Our Ref: CM/11/22/NMA

Non material amendment following the grant of CM/6/20/PL for changes to approved plans, 2
No additional windows to ground floor on eastern and western elevations, porch to entrance of
property and provide a dormer window on eastern side of first floor.

North Barn Climping Street Climping BN17 5RG

PROPOSED EAST ELEVATION

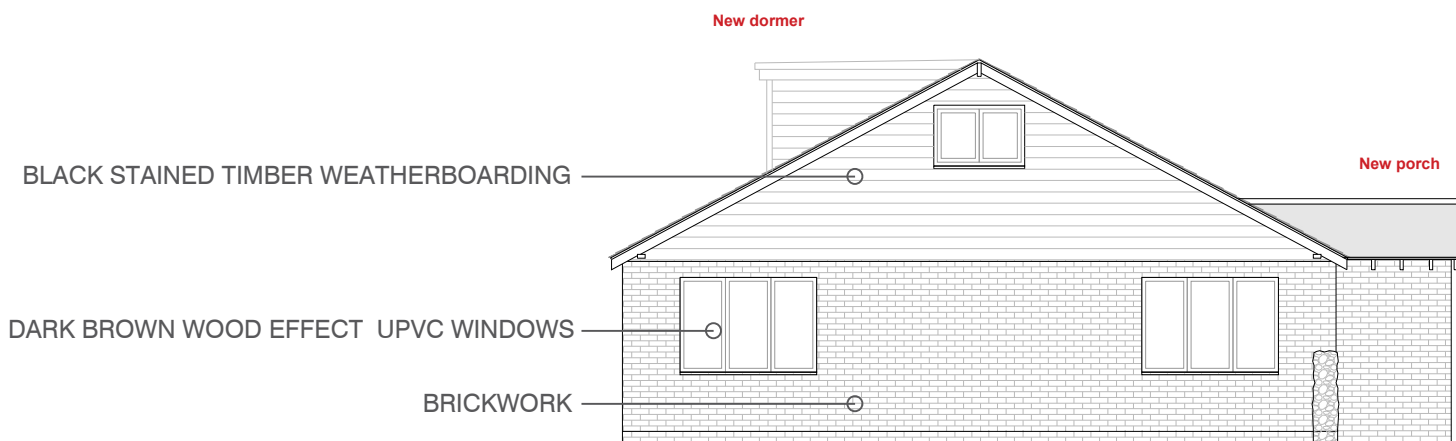
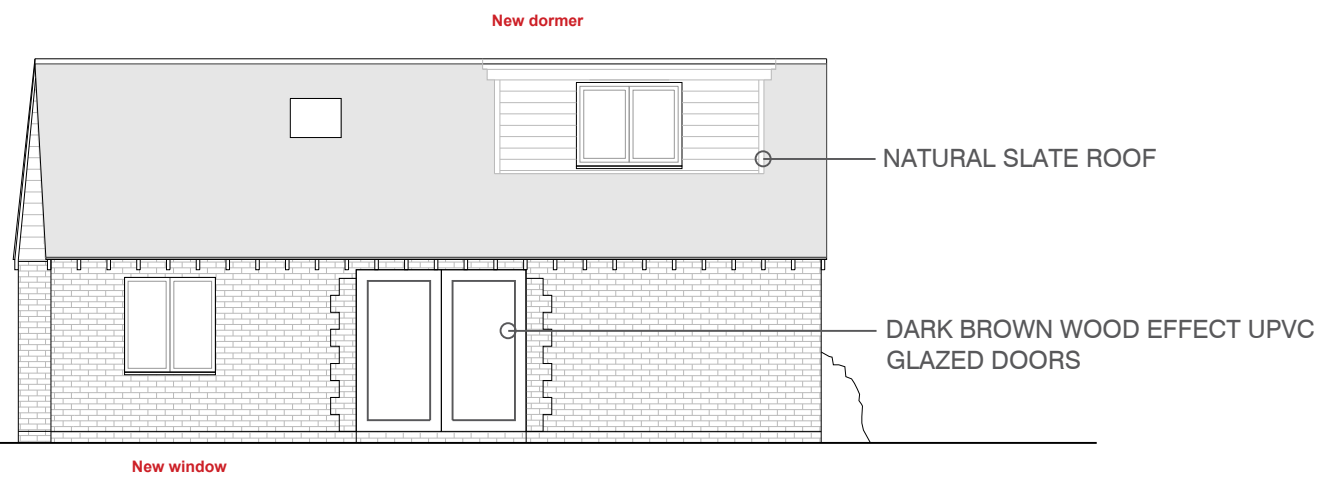
The reasons that these proposals have not been accepted as Non-Material Amendments is because the addition of a porch and first floor dormer materially altering the appearance of the building, and extend it beyond recommended criteria, and it cannot therefore be considered under section 96A of the Town and Country Planning Act 1990.
